PLANNING CONSULTATION RESPONSE

Application No	2026/0480
Proposal	Erection of a detached bungalow and associated works including subdivision of residential garden and alterations to parking arrangements (Custom/Self-Build)
Address	66 Longley Street, Barugh Green, Barnsley, S75 1NT
Date of Consultation Reply	29/06/2026
Consultee	Katie Lawrence, Planning Ecologist

REV	DESCRIPTION	DATE
DEVELOPMENT		
LAND ADJACENT TO 66 LONGLEY STREET, BARUGH GREEN		
DRAWING TITLE		
PROPOSED ELEVATIONS		
DATE	SCALE	DRAWN
25.04.26	1:100@A3	WS
DRAWING REF	REV	
LS-NB-PE-01	-

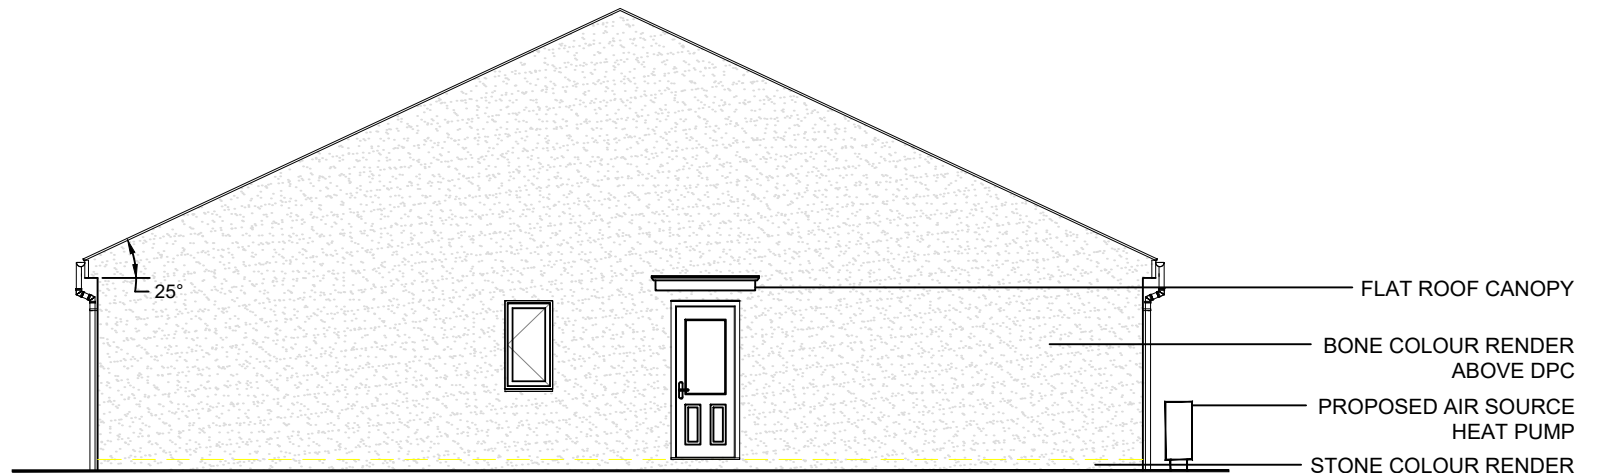
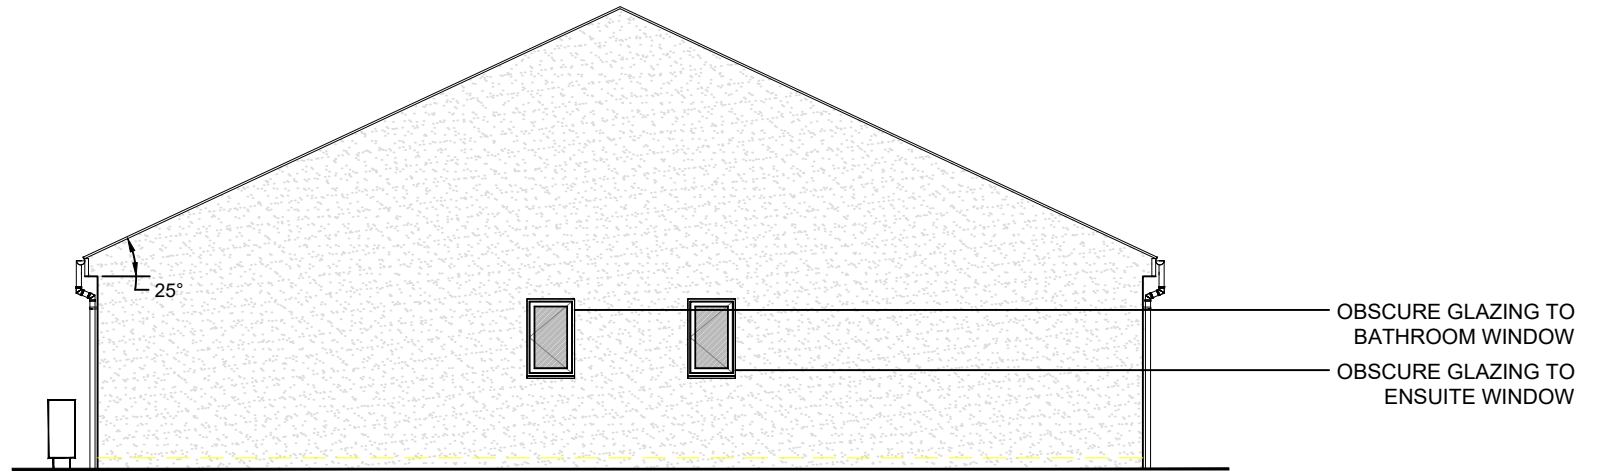
- As per the Biodiversity and Geodiversity SPD and NPPF the proposed dwelling should incorporate integral bat and bird boxes. This can be secured either by proposal plans being updated with suggested locations and types of the boxes indicated or by a planning condition, with suggested wording below.

Notwithstanding the submitted details, before above ground works commence a scheme for biodiversity enhancement, such as the incorporation of permanent bat roosting feature(s), and nesting opportunities for birds, shall be submitted to and agreed in writing with the Local Planning Authority. The approved details thereafter shall be implemented, retained and maintained for their designed purpose in accordance with the approved scheme.

A	EXISTING AND PROPOSED SEWERS SHOWN ON PLAN. ROOF HATCH UPDATED FOR PROPOSED PLOT.	29.07.26
REV	DESCRIPTION	DATE
DEVELOPMENT		
LAND ADJACENT TO 66 LONGLEY STREET, BARUGH GREEN		
DRAWING TITLE		
PROPOSED SITE LAYOUT		
DATE	25.04.26	SCALE 1:250@A3
DRAWN	WS	
DRAWING REF	LS-NB-PSL-01	REV A

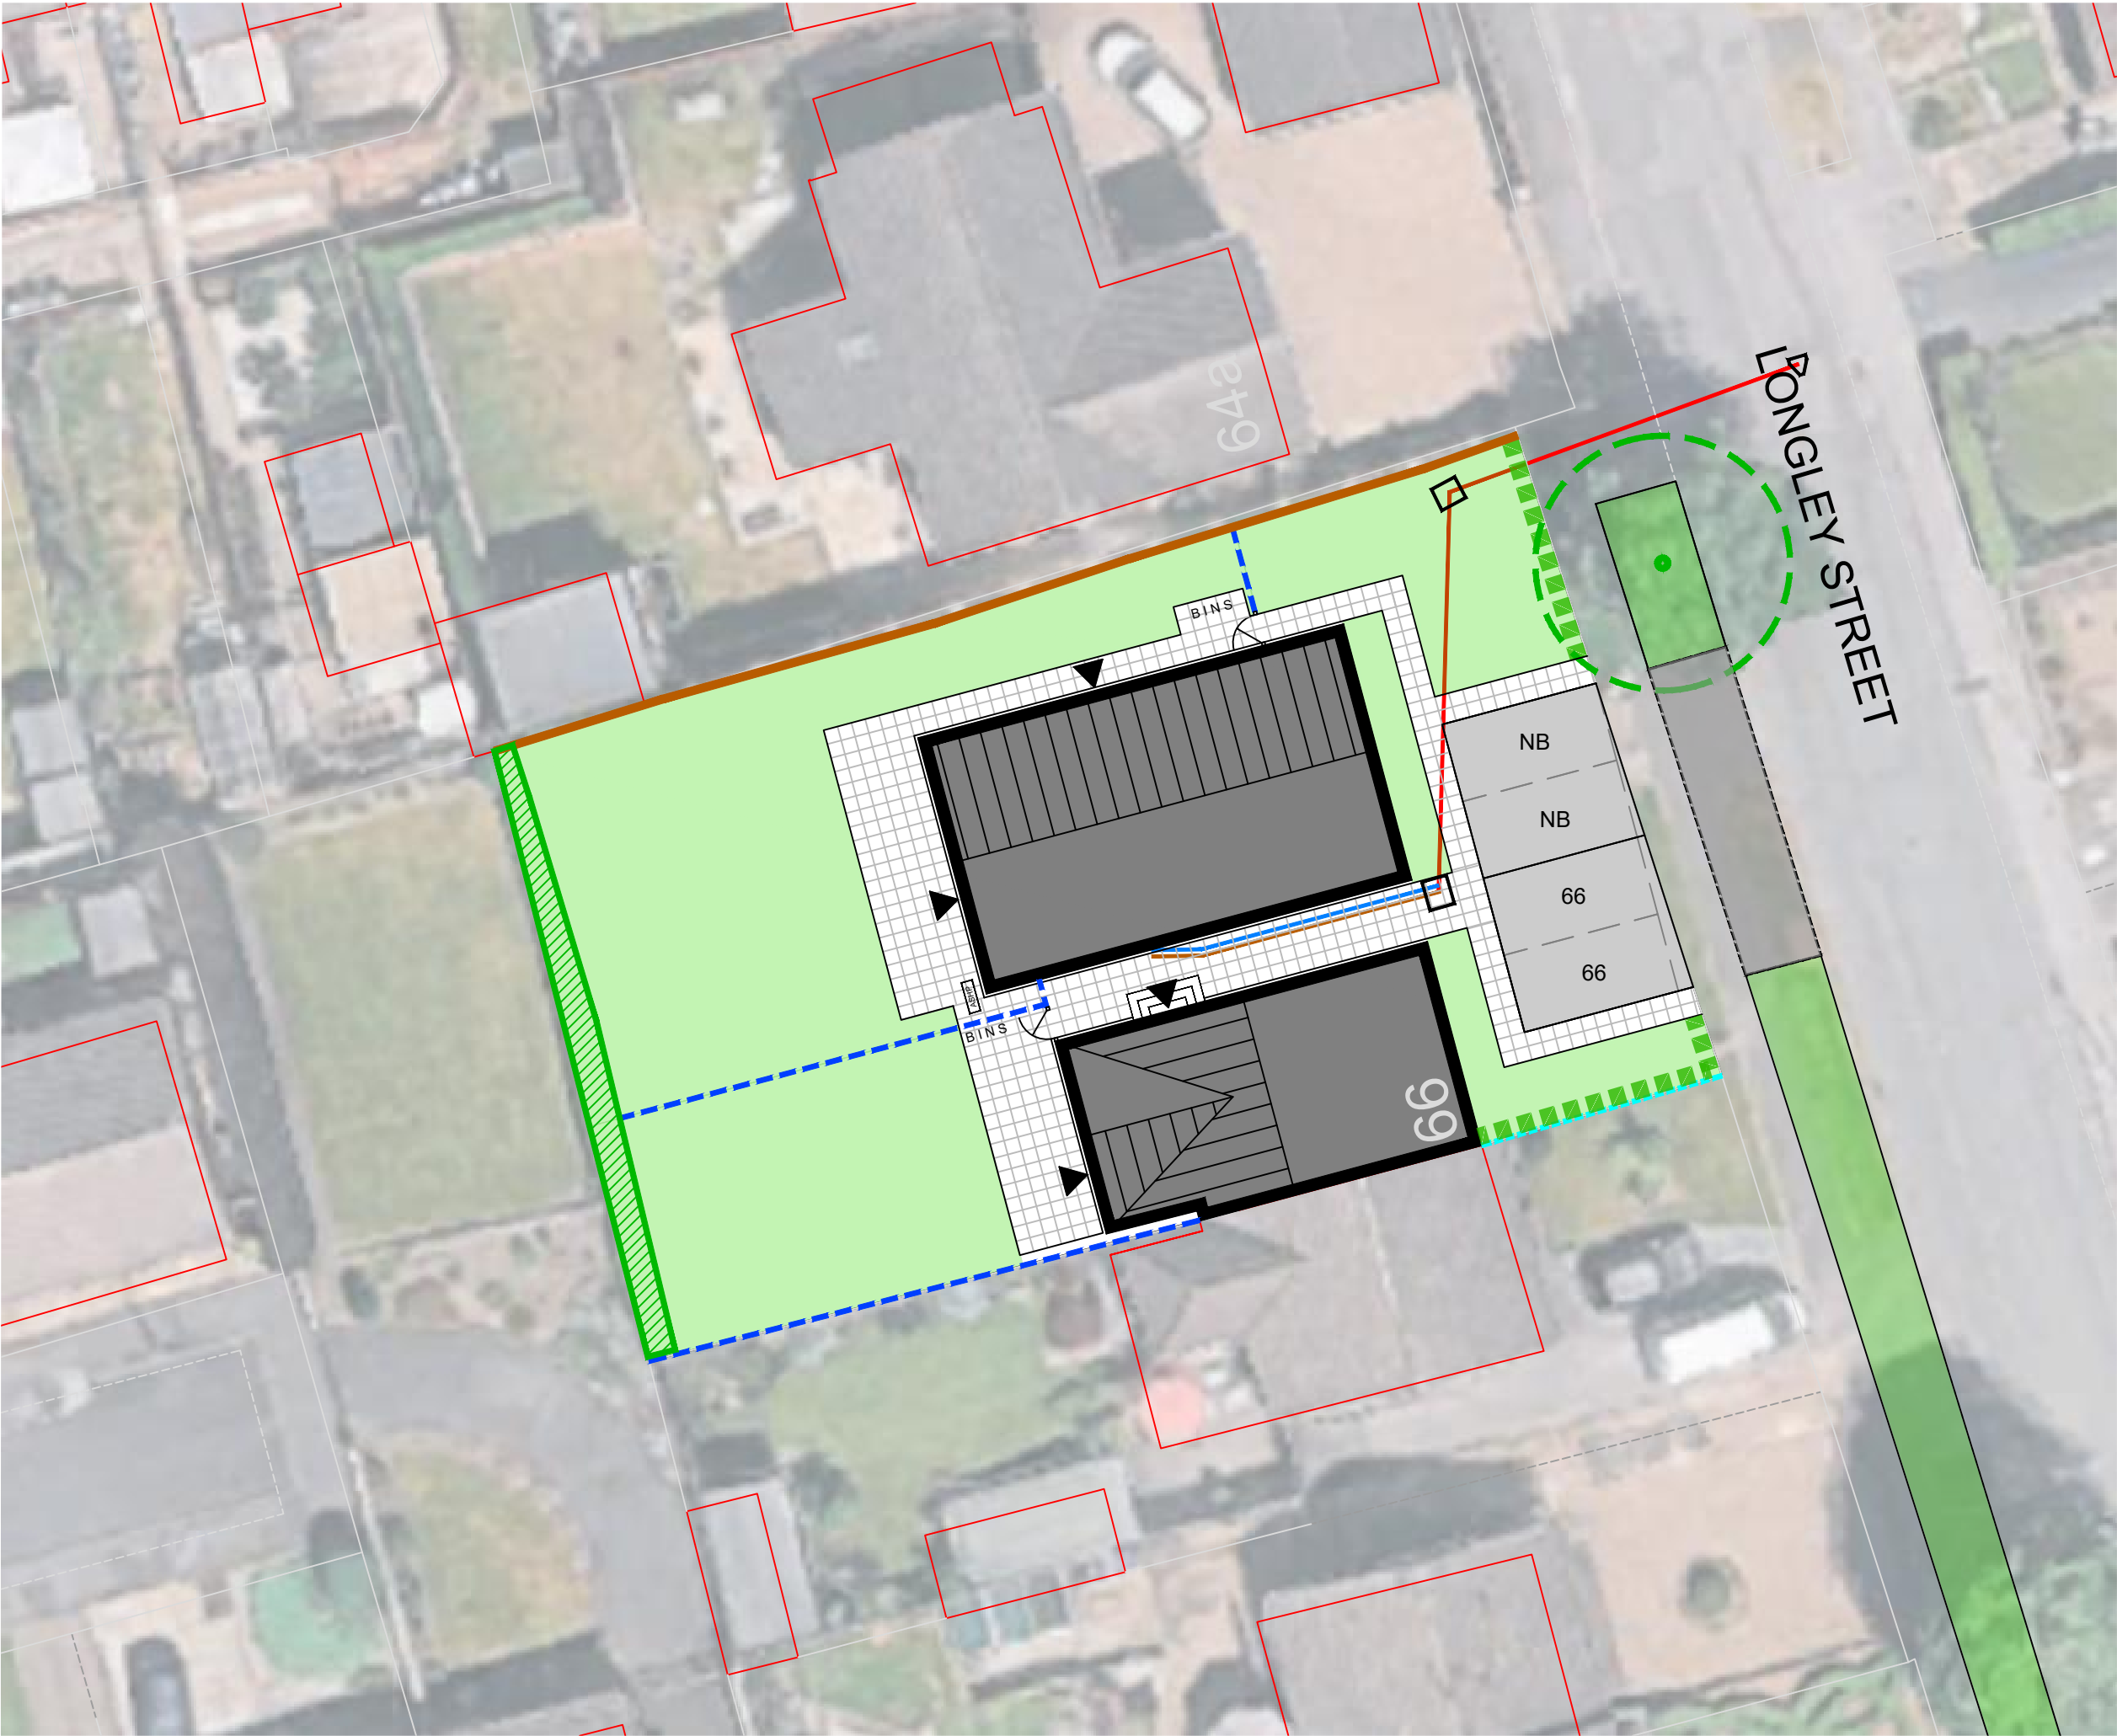
- When referring to the proposed site layout plan it appears as though shrubs within the current garden will be lost to the proposals and it is therefore suggested that an informative relating to nesting birds is included within the permission notice, if granted to ensure the legislation afforded to such species is adhered to.
